Final Report - Corrections Required Application No. ANEX-23-0014

Description : A request by Norris Ranch Joint Venture, LLC, for annexation of 19.605 acres into the City of Colorado Springs. The annexation is a part of the overall Karman Line Land Use Plan, which is being submitted concurrently. The Land Use Plan proposes a maximum of 6,500 dwelling units, approximately 45 acres of light industrial, 105 acres of commercial/retail, 100 acres of mixed-use development, and 570 acres of park/open space.

Document Filename : Annexation Plat_Rev

SHEET 5

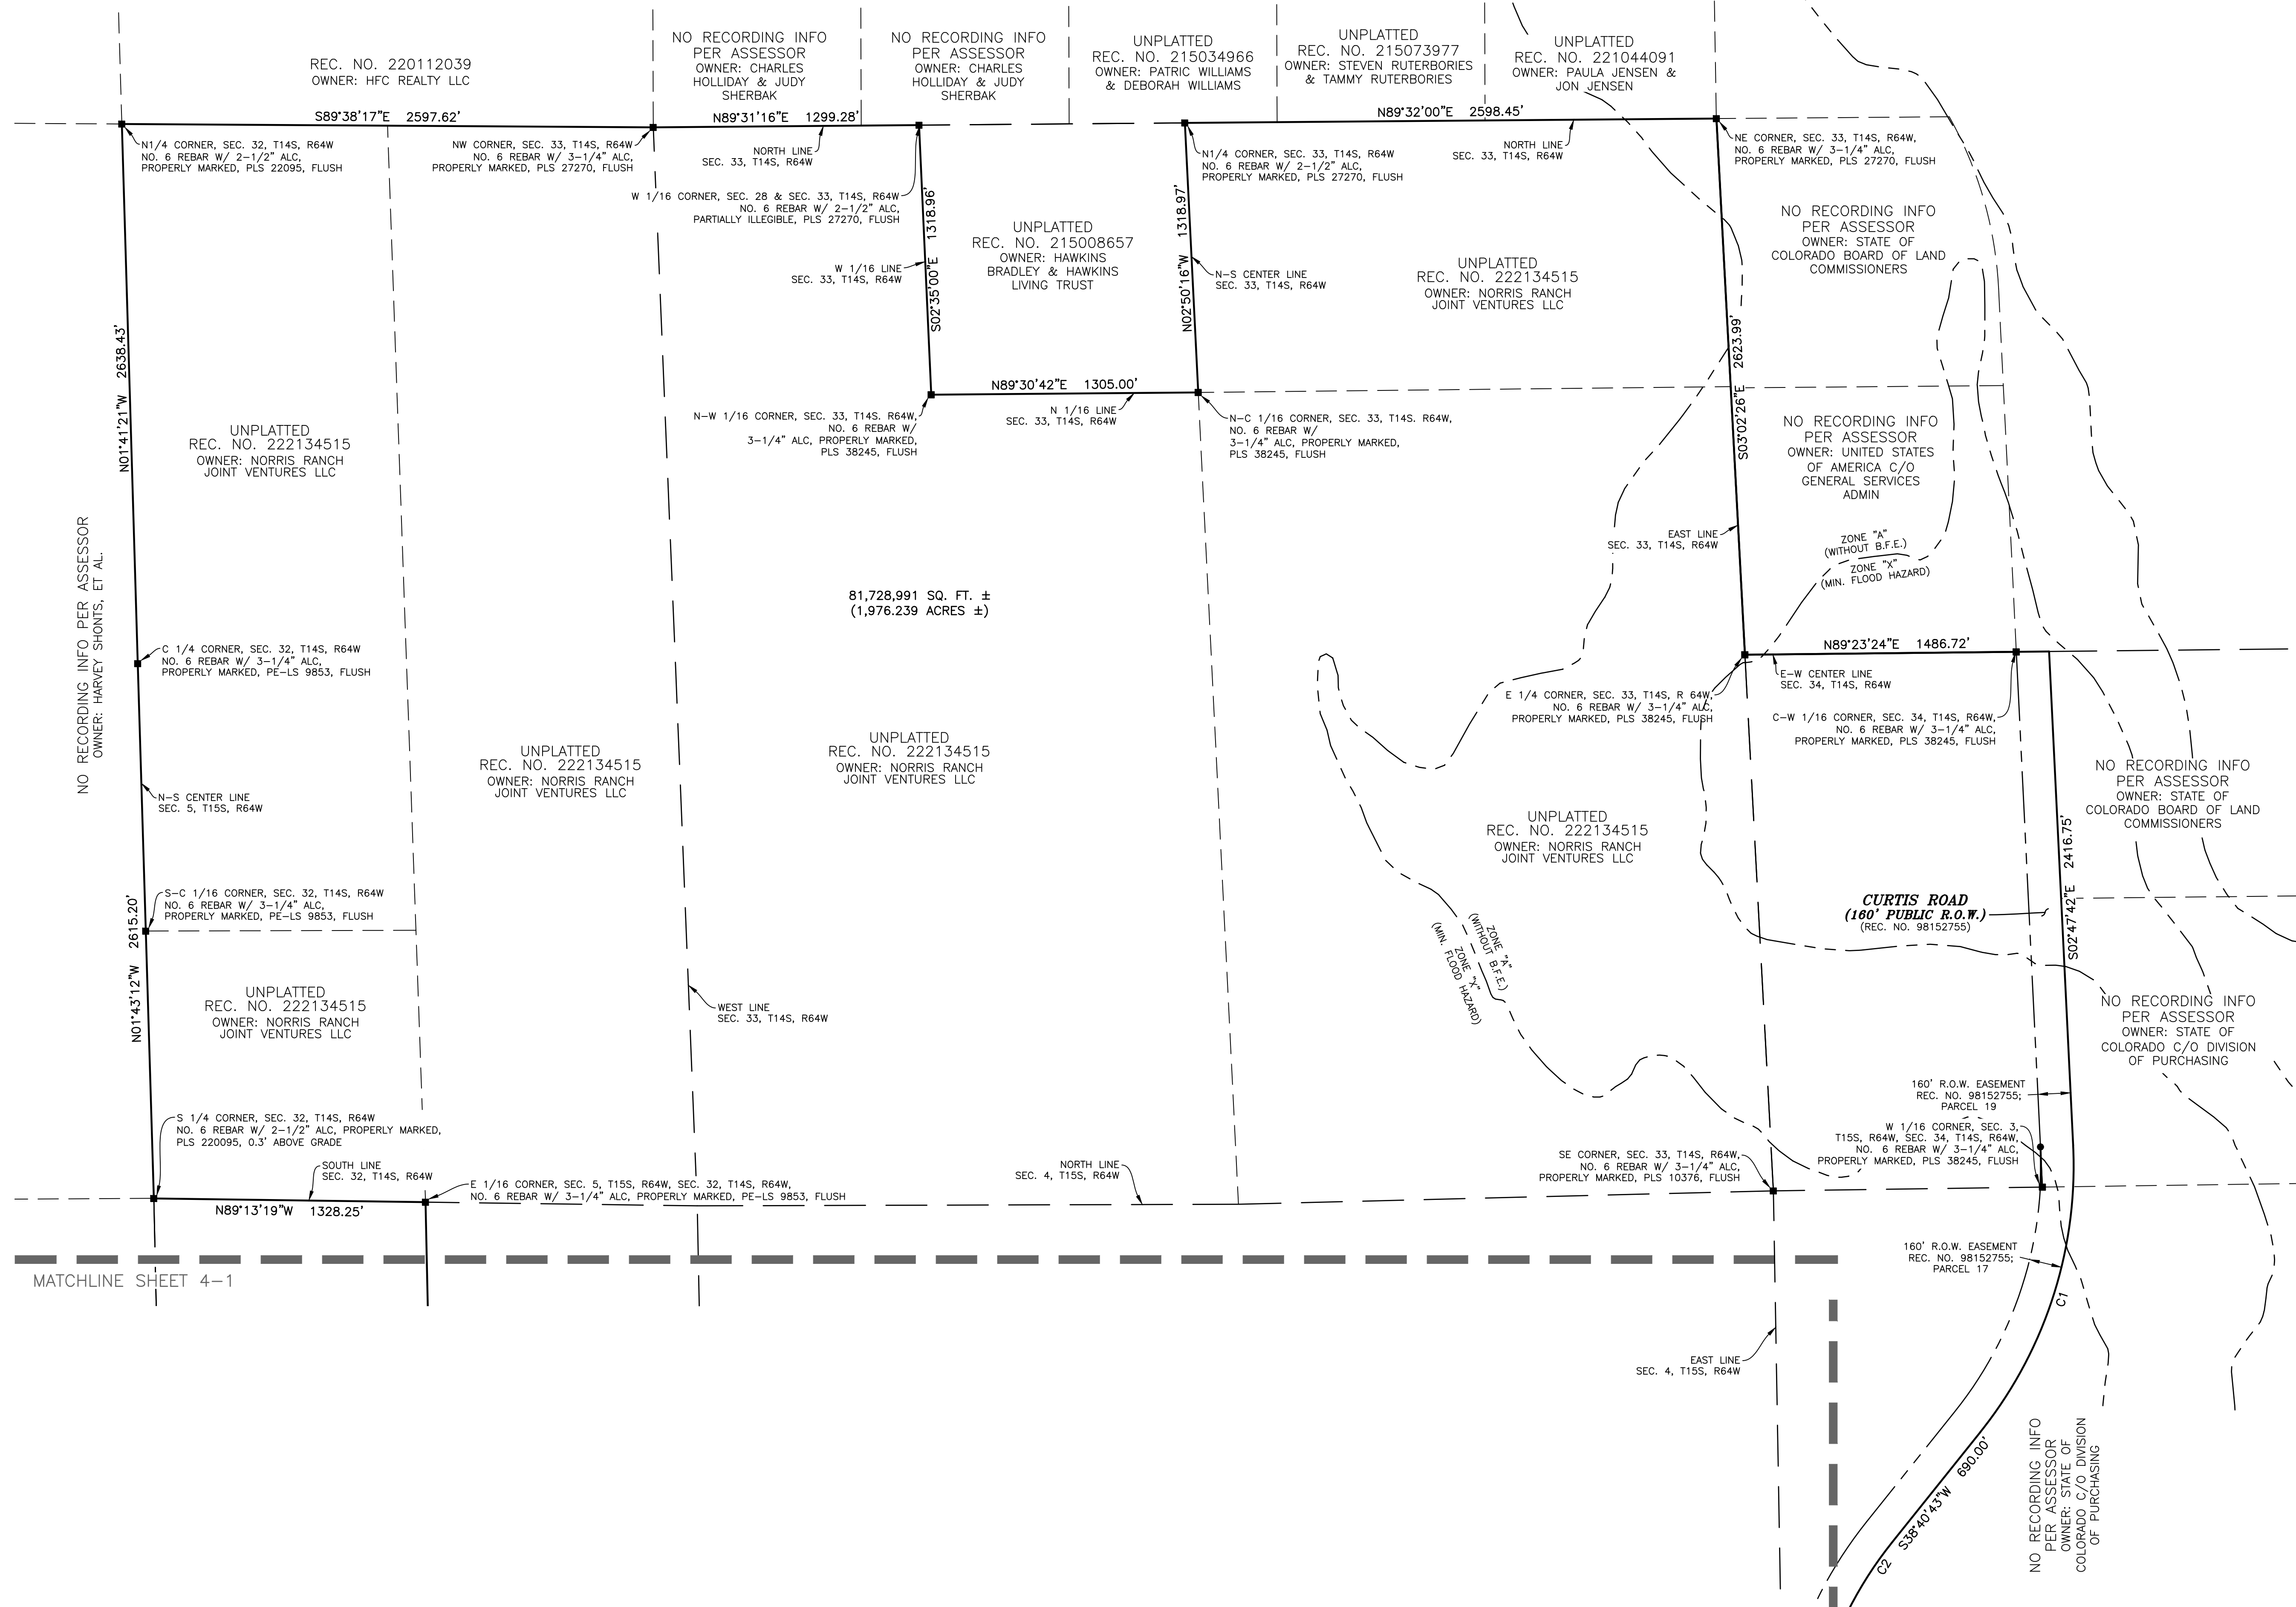
Please add the distance
2651.22' from the adjacent
sheet along this line

Please depict the
continuation of Curtis
Road north of this area

Please depict and
label the roadway
going to the east
